Office of
Environment
& Heritage

Your reference: PA 08_0111 MOD3
Our reference: DOC13/72905; FIL12/7304
Contact: Robert Gibson, 4908 6851

RE: MODIFICATION 3 - AUSTAR LWA7-A10 MODIFICATION, STAGE 3 AREA - ENVIRONMENTAL ASSESSMENT (PA 08-0111 MOD 3)

ATTACHMENT 1: OEH COMMENTS AND RECOMMENDED CONDITIONS OF APPROVAL

FIGURE 7.1
Proposed Biodiversity Offset Area

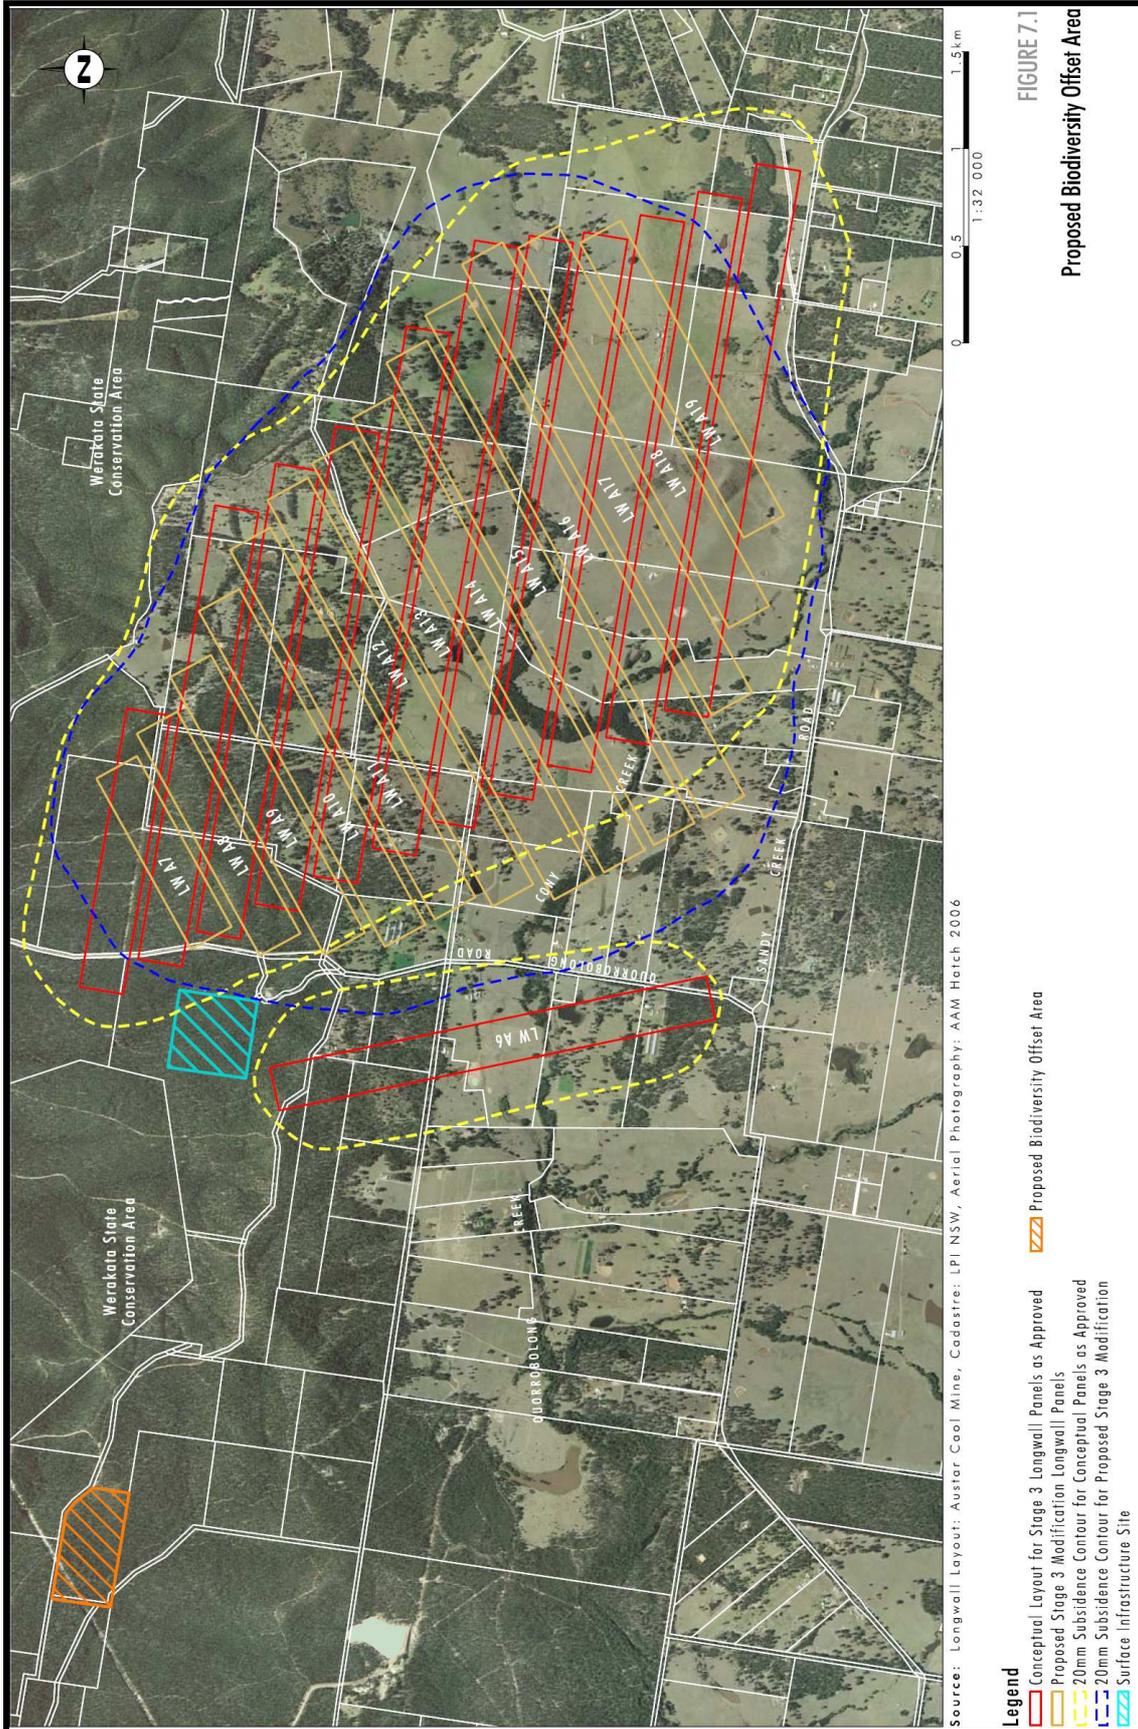
'Austar Coal Mine will establish and manage the proposed Biodiversity Offset Area (refer to Figure 7.1) to protect and enhance its ecological values in perpetuity, to the satisfaction of the Director General'.

However no details of this proposed biodiversity offset area are referred to anywhere else in the EA, and Figure 7.1 is not presented. OEH requests that further details of this proposed offset package are provided.
